Our Ref: BN/115/19/HH
Your Ref:

Town & Country Planning Act 1990 (as amended)
Town & Country Planning (Development Management Procedure) (England) Order 2015
Application for Planning Permission for Works or Extension to a Dwelling

Development Single storey side and rear extension and porch to front
Location Croft Cottage Park Road Barnham

PROPOSED SITE PLAN
scale 1:200

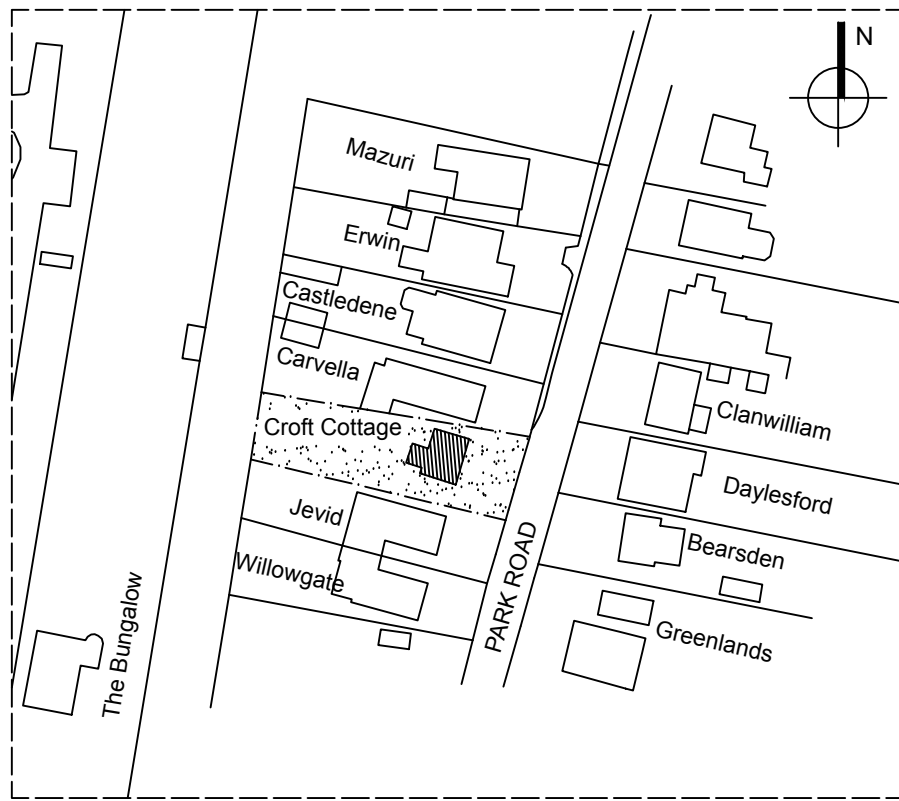
Single storey side and rear extension and porch to front
Block Plan

You are required to include dimensions from the proposed extensions to the site boundaries on the block plan. Please amend.

Location Plan: You are required to have a solid red outline around the proposal site with no gaps in the outline.
